WATERVIEW 2020 SKETCH PLAN AMENDMENT

PCD PROJECT NO. SKP-20-002
EA19133

Sketch Plan_v2_redlines.pdf Markup Summary

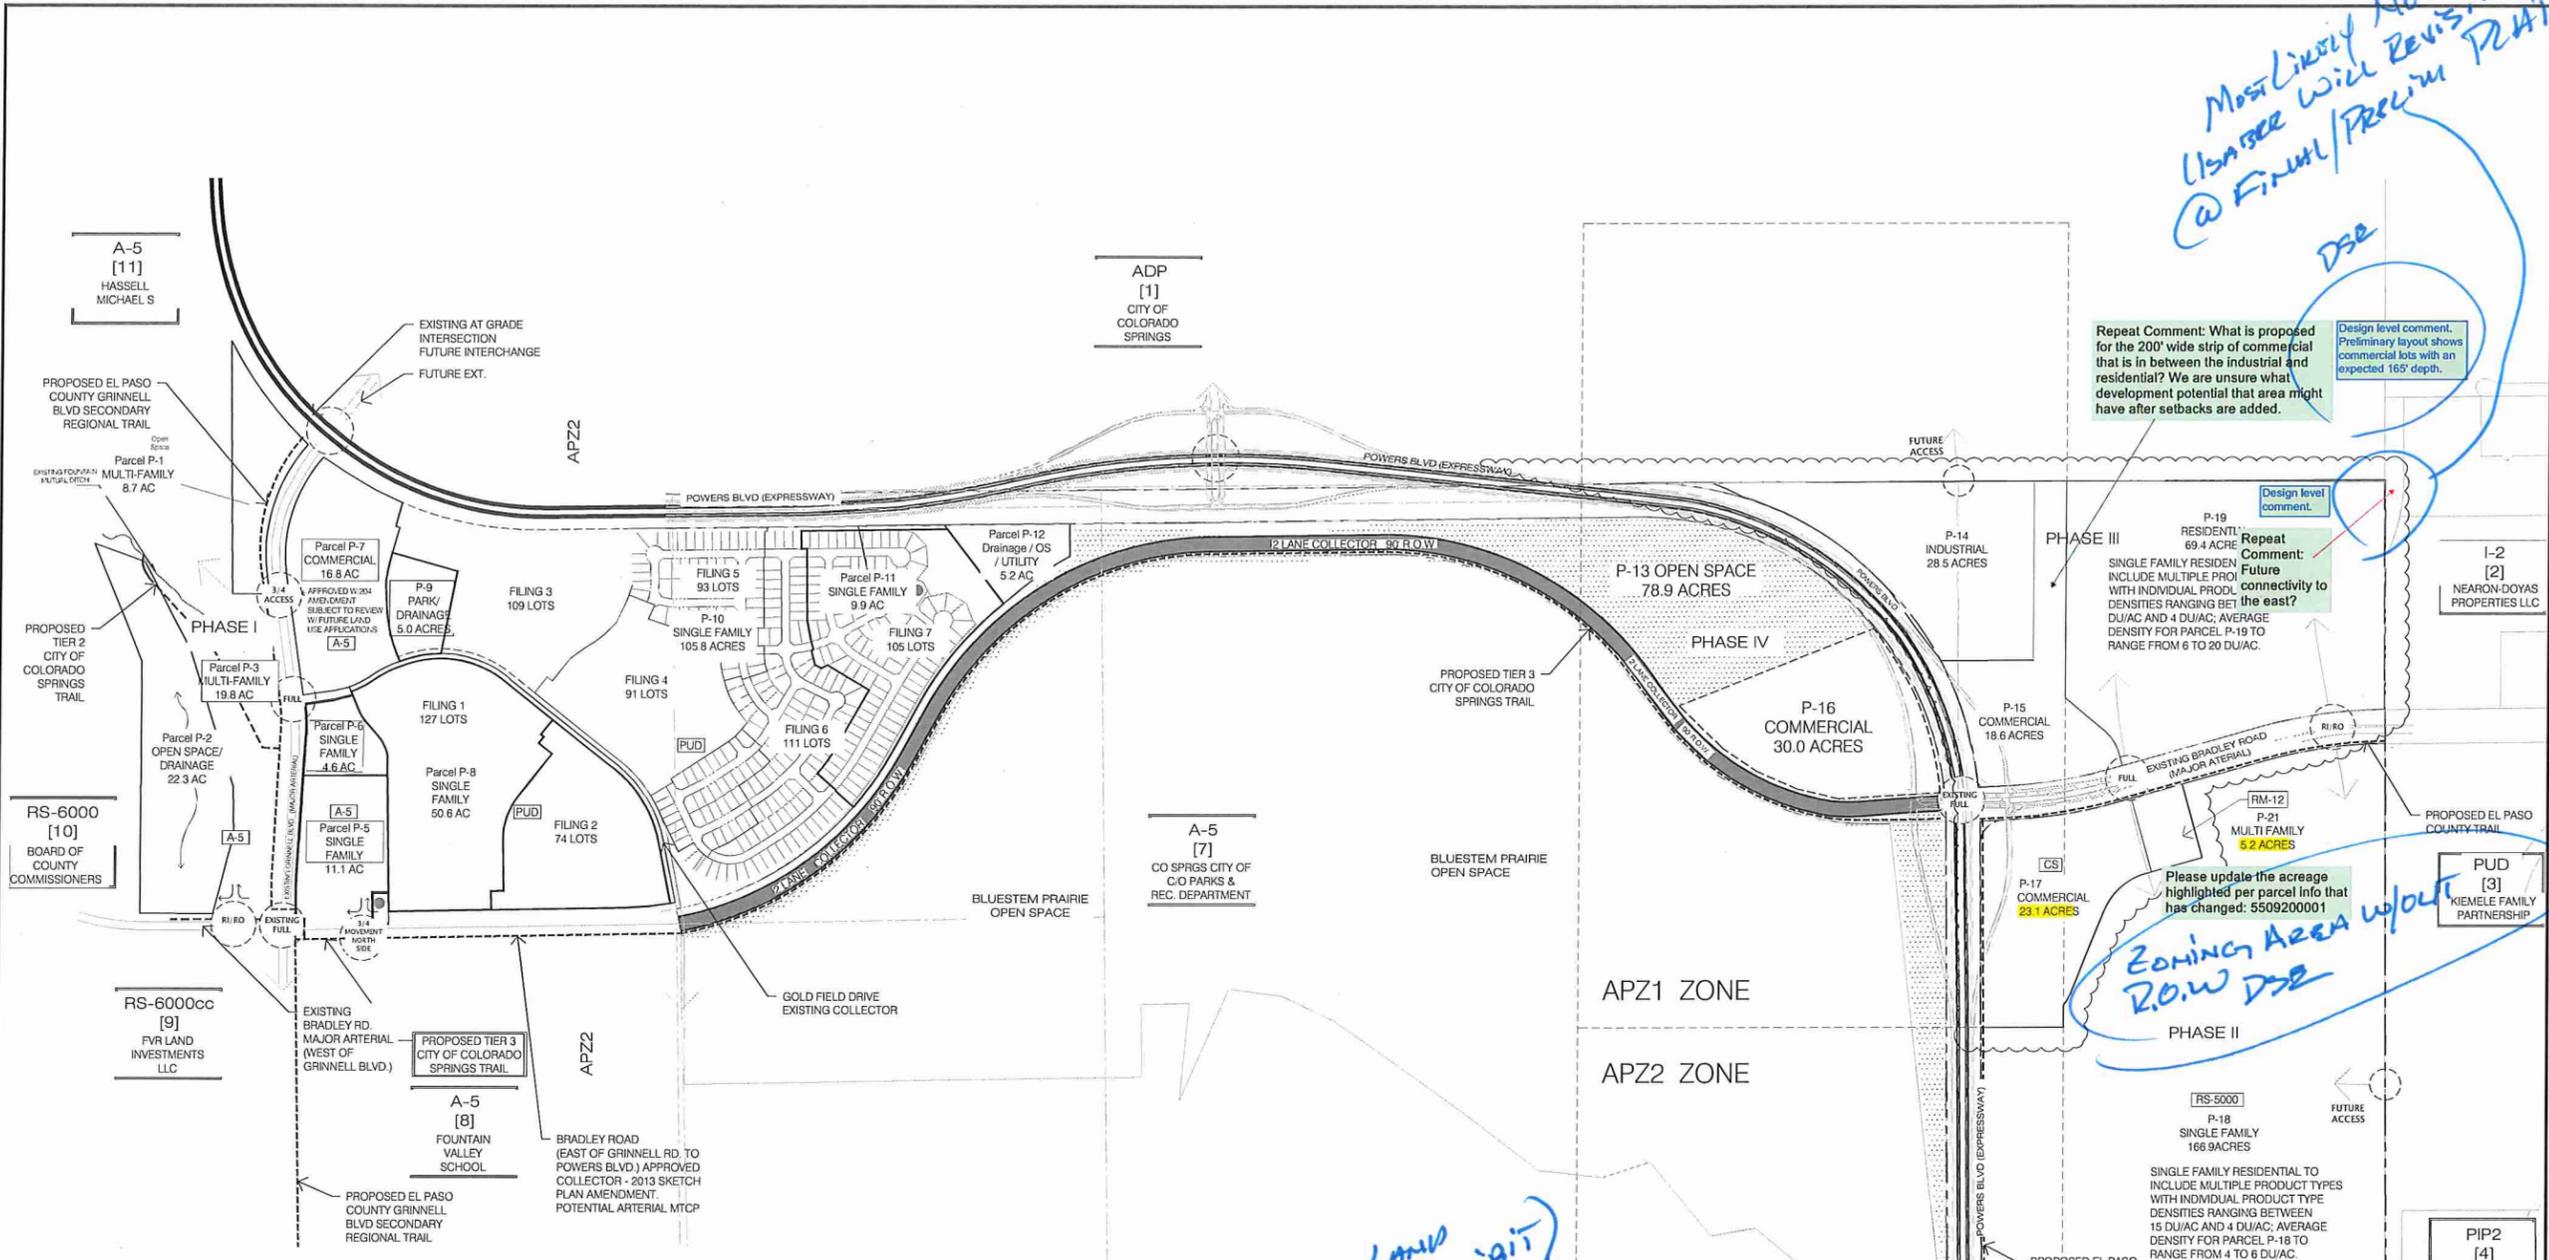
Repeat Comment: What is proposed for the 200' wide strip of commercial that is in between the industrial and residential? We are unsure what development potential that area might have after setbacks are added.

Repeat Comment: Future connectivity to the east?

Please update the acreage highlighted per parcel info that has changed: 5509200001

COVER SHEET

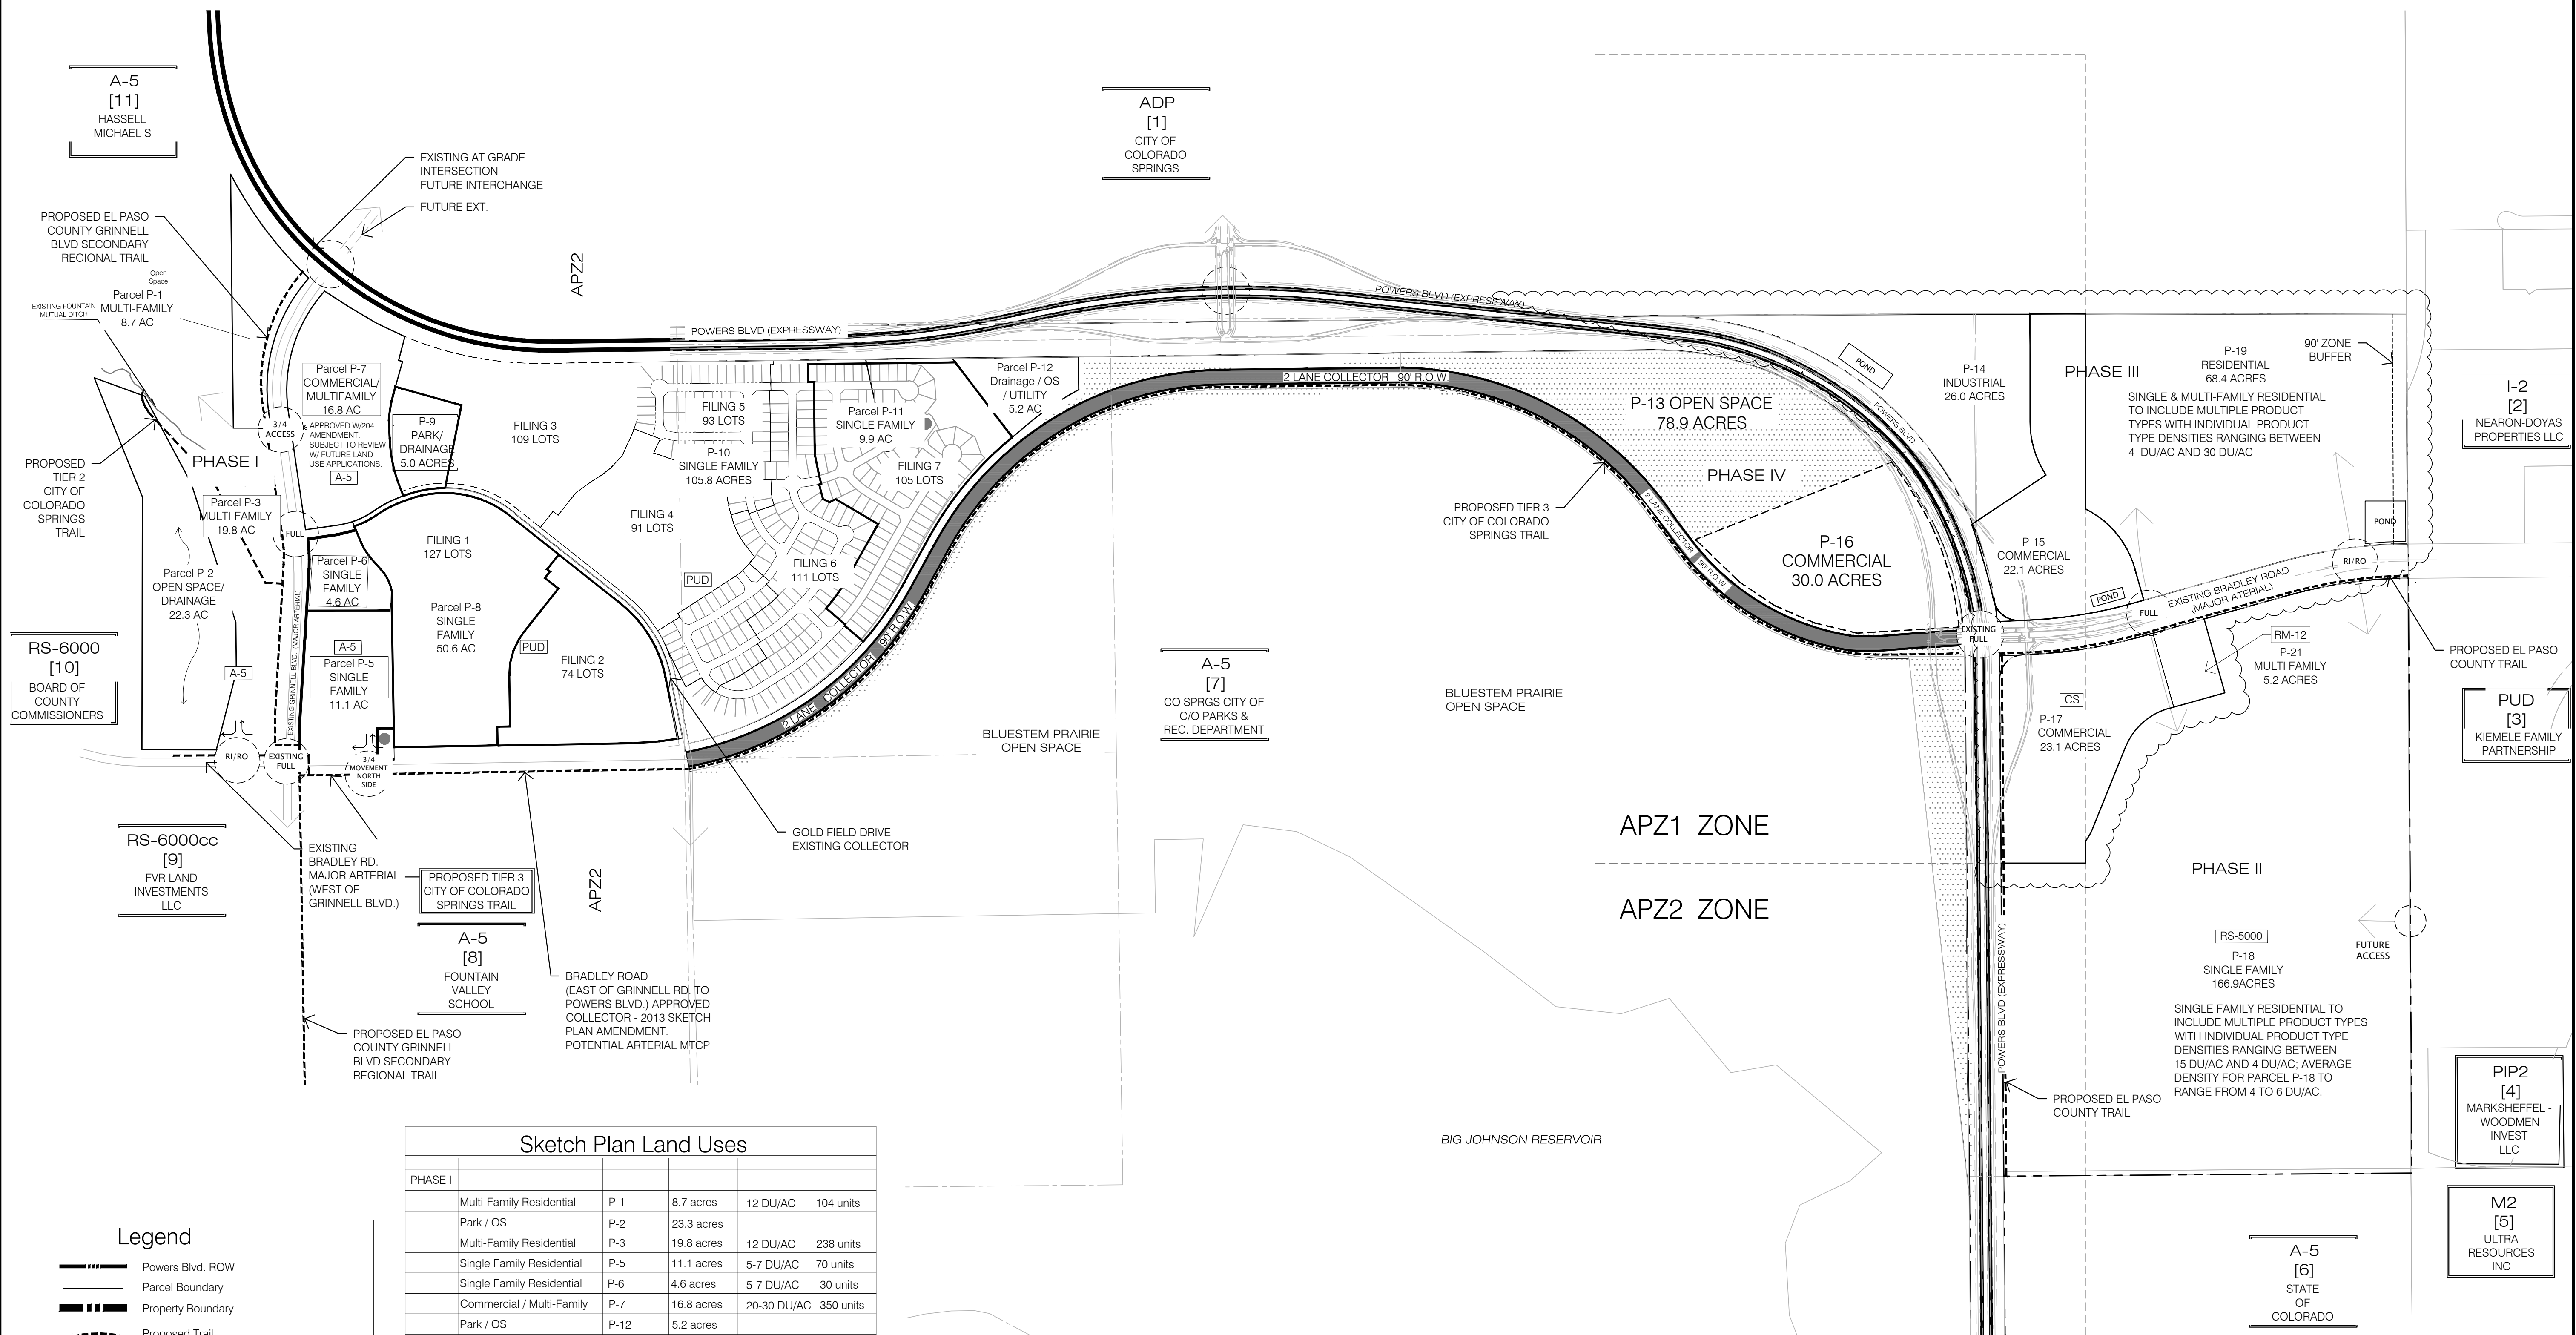
Repeat Comment: Please add the CAD-O to reflect this is within the airport overlay.

Please update highlighted area per the recent parcel change for 5509200001

The assessor reflects this parcel has changed. The parcel is now 5509200001 and the acreage and owner information has changed. Please revise.

Please update the legal description as needed to capture the revision to Parcel 5509200001

Please correct highlighted fields to reflect the applicable PUD.
